**City of Portland, Maine - Building or Use Permit Application**

Location of Construction: 134 NOYES ST	Owner Name: BURROWS DONALD C & PATRI	Owner Address: 134 NOYES ST
Business Name:	Contractor Name: Scott Forbes 772-3380	Contractor Address: 188 Capisic Street Portland, ME 04102-3380
Lessee/Buyer's Name:	Phone:	Permit Type: Additions - Dwellings

Past Use: Single Family Home	Proposed Use: Single Family Home / add 1 story approx. 18' x 20' attached garage	Permit Fee: \$201.00	Cost of Work: \$20,000.00	CEO District: 3
---------------------------------	---	-------------------------	------------------------------	--------------------

**Dept:** Zoning      **Status:** Approved with Conditions      **Reviewer:** Tammy Munson      **Approval Date:** 09/14/2005

CONST. PLAN

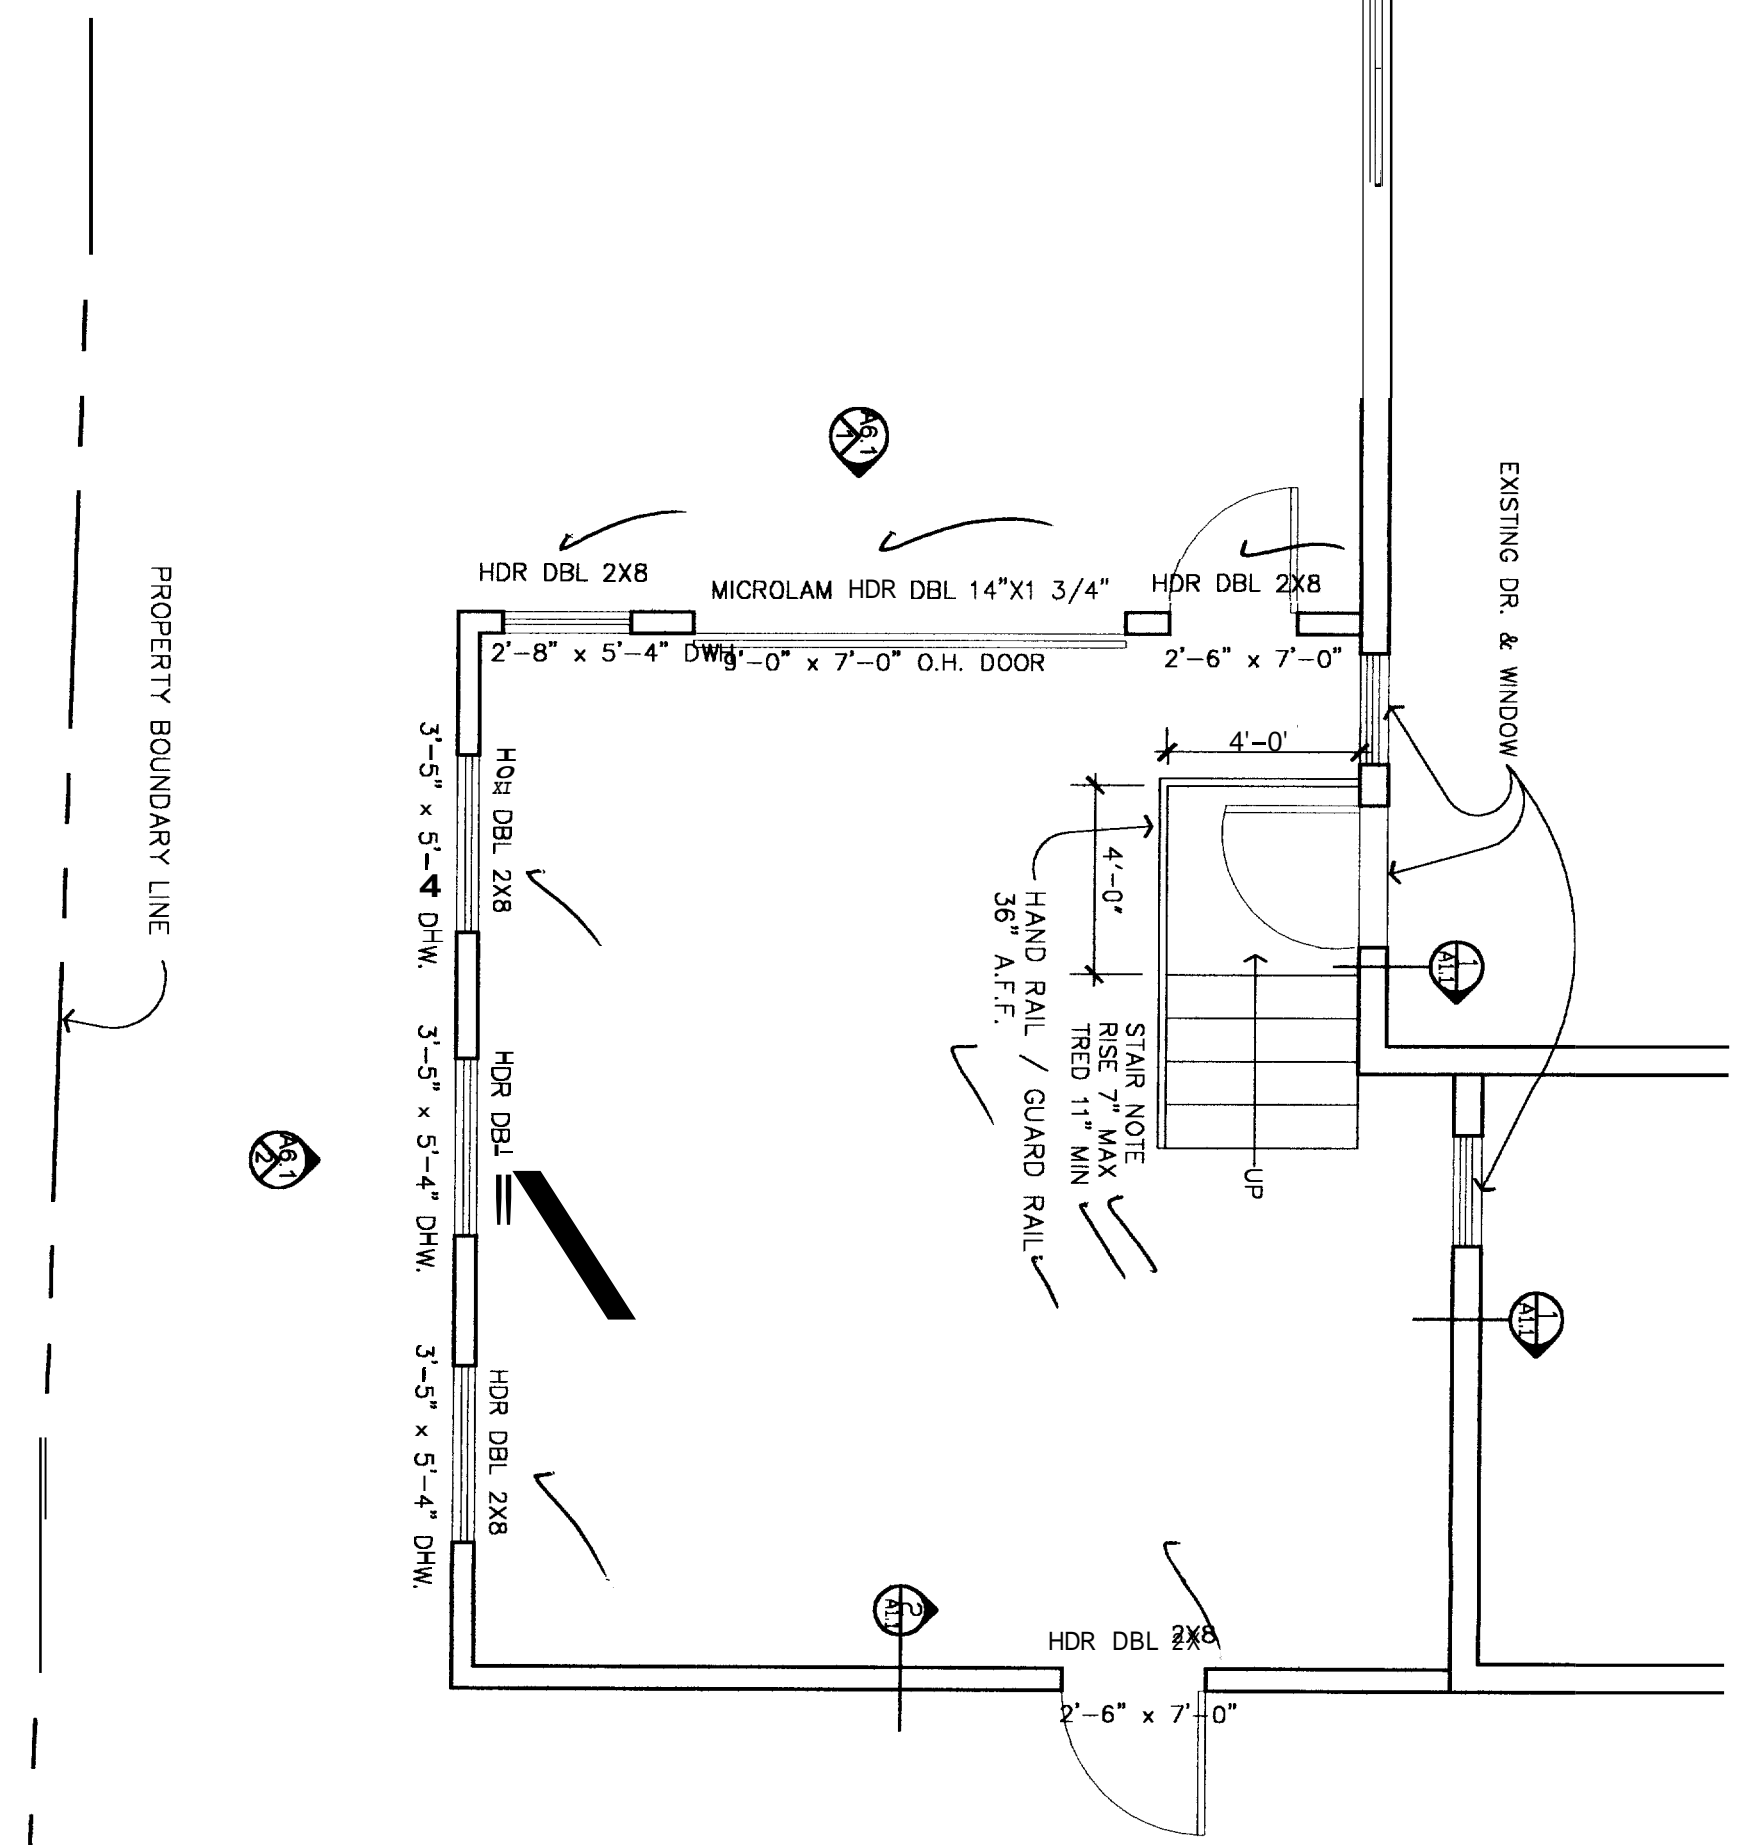
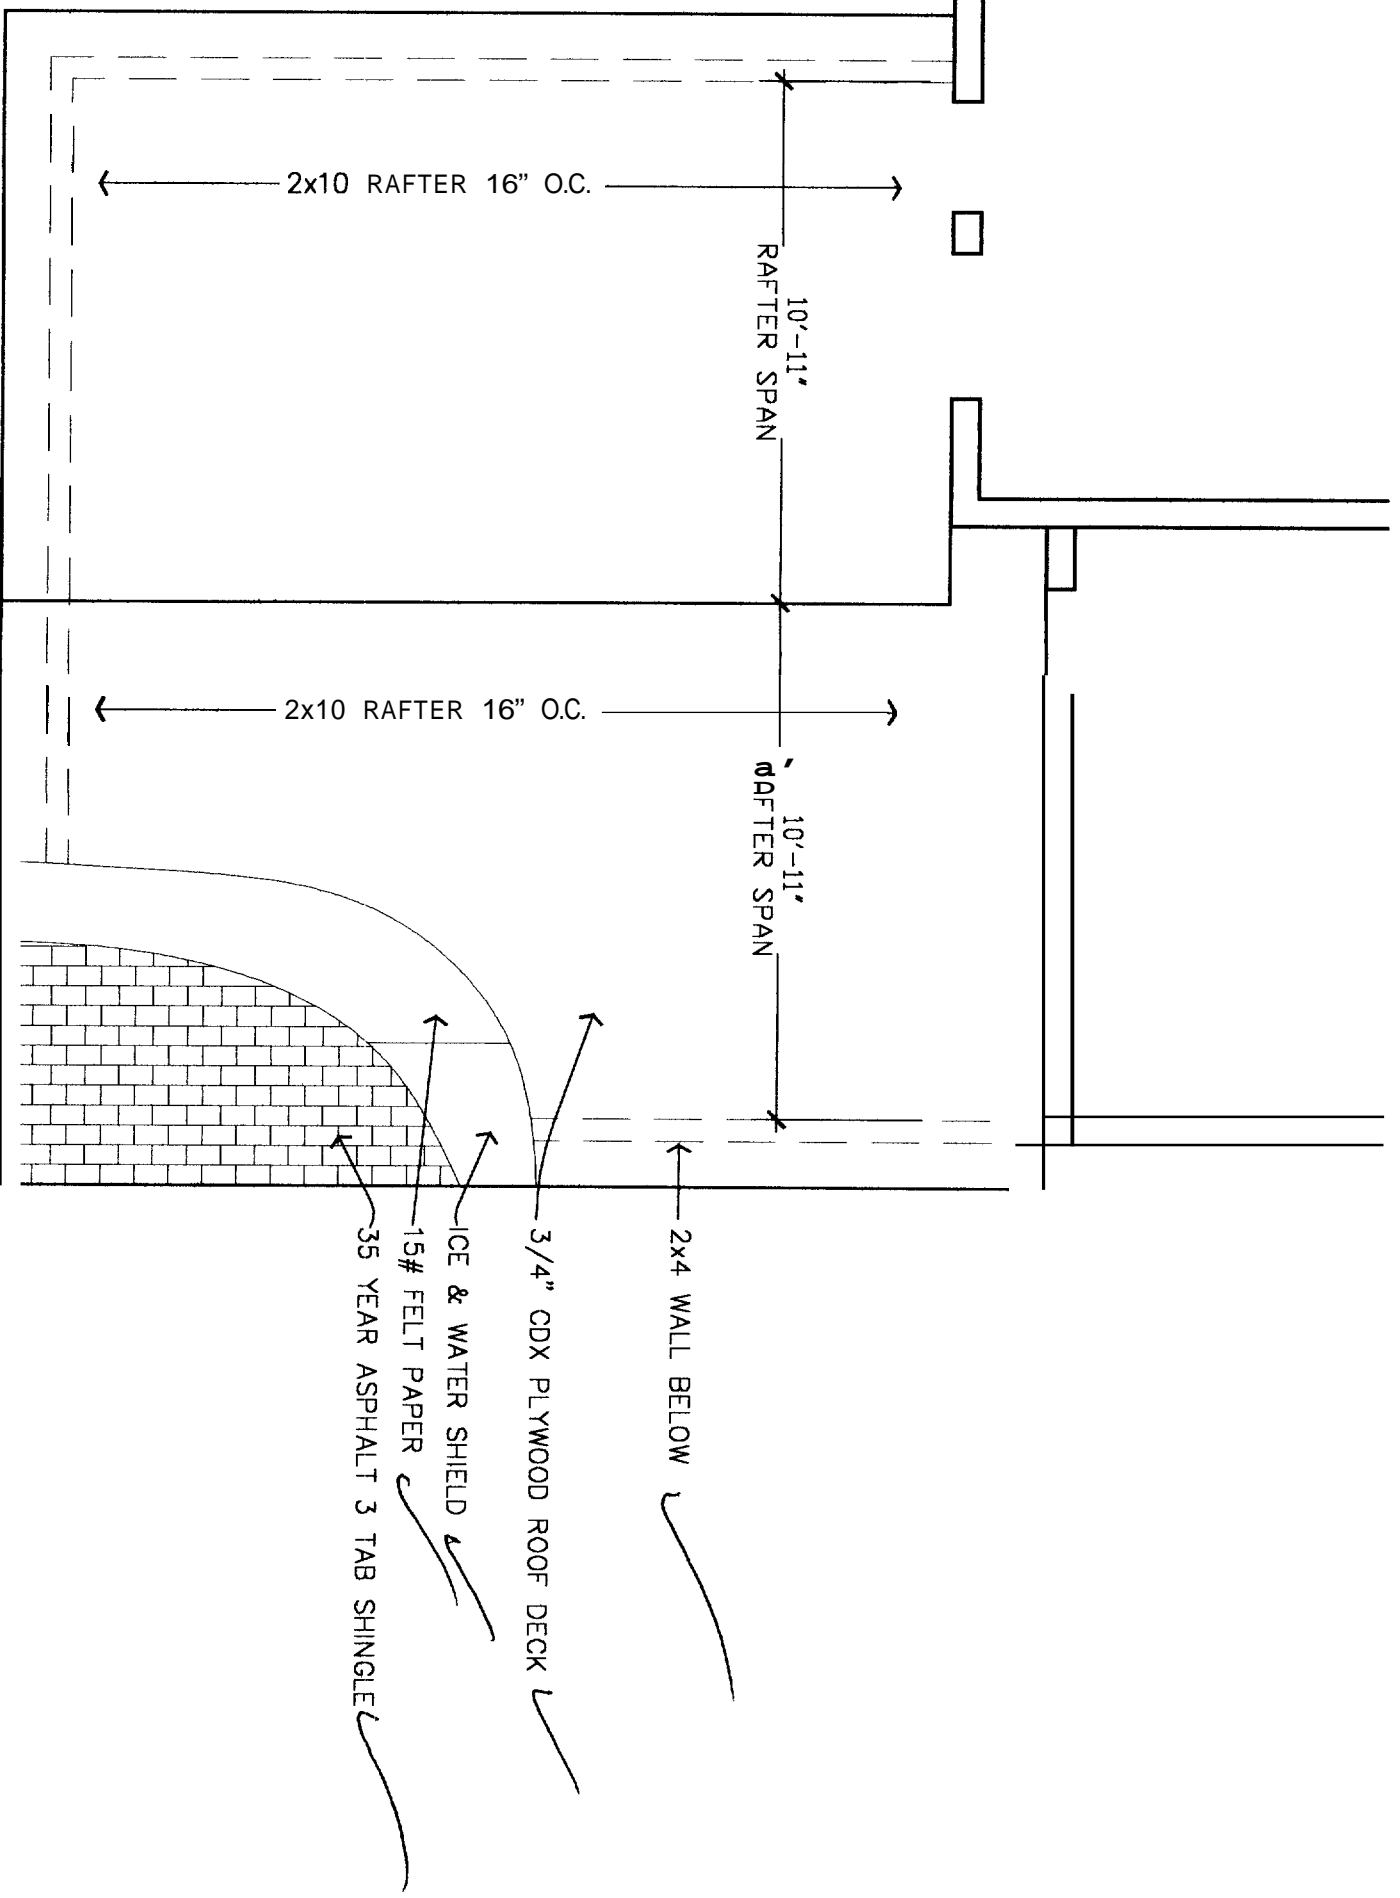
- 1) The existing windows in the common garage/house walls MUST be removed and dywalled with 1/2" sheetrock.
